Application for Planning Permission for Works or Extension to a Dwelling

Development: Single storey rear extension with steps.
Location: 20 Pine Trees Close Angmering BN16 4LT

PROPOSED WEST ELEVATION 1:100

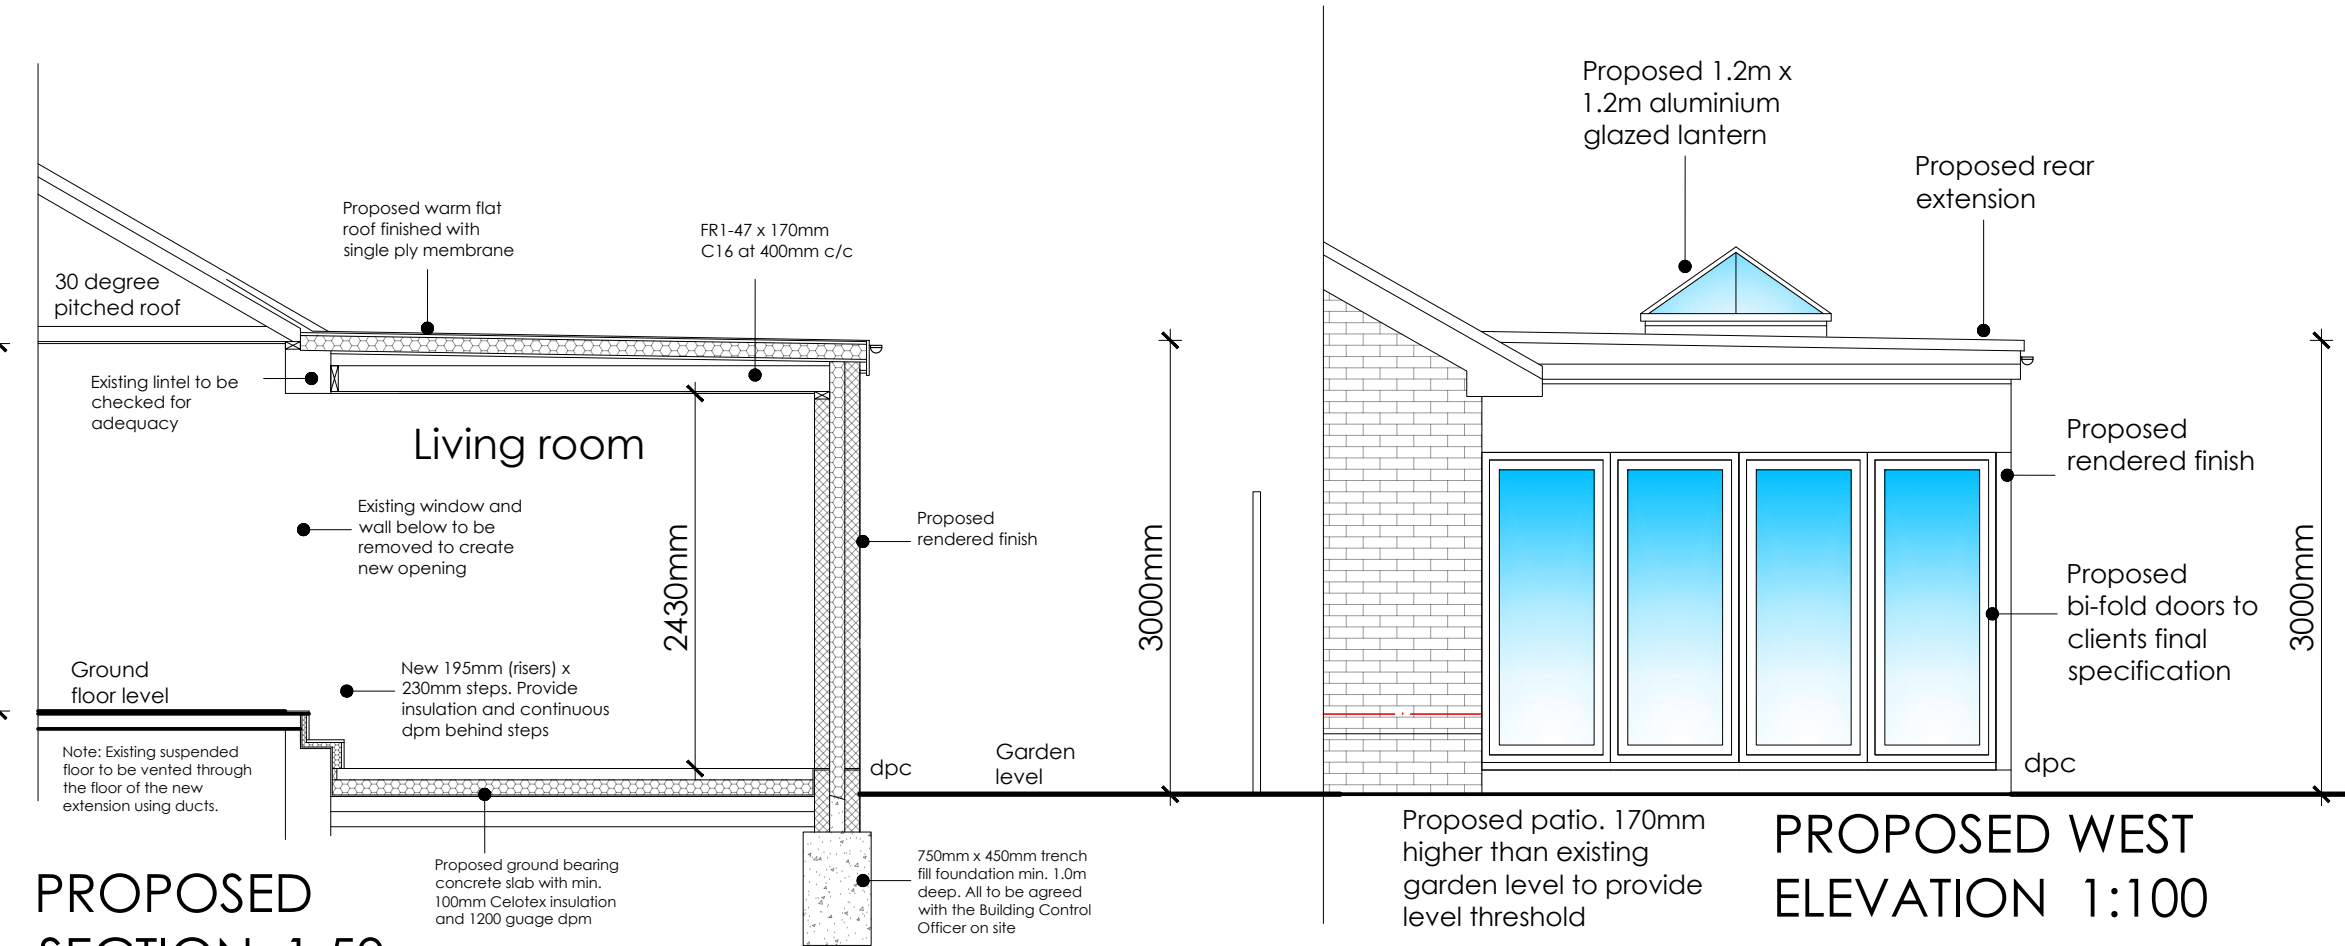
Propose West Elevation

The proposed part west elevation appears to measure to a scale of 1:50, however the scale listed is 1:100. Please review and amend.

SITE PLAN
1:500

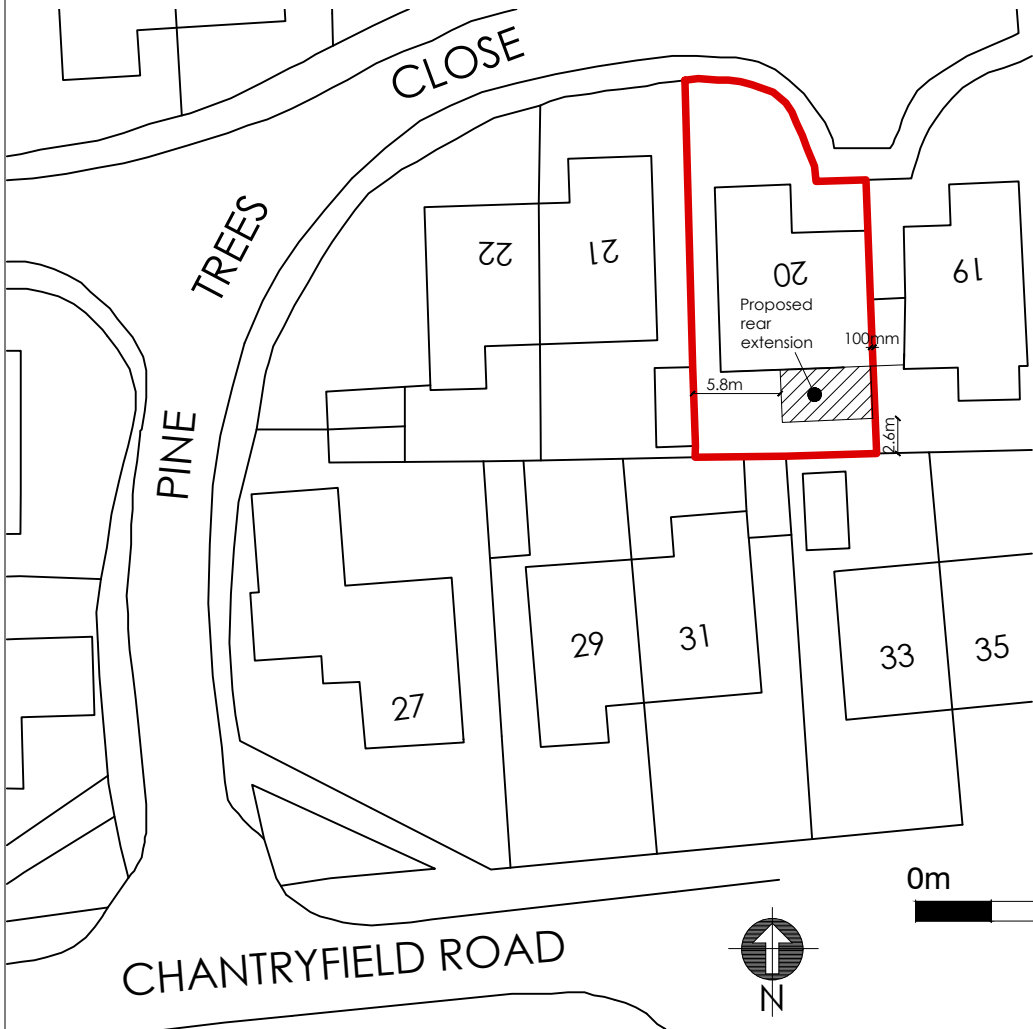
Block Plan

You are required to have dimensions from the proposed extension(s) to all site boundaries. Please amend.
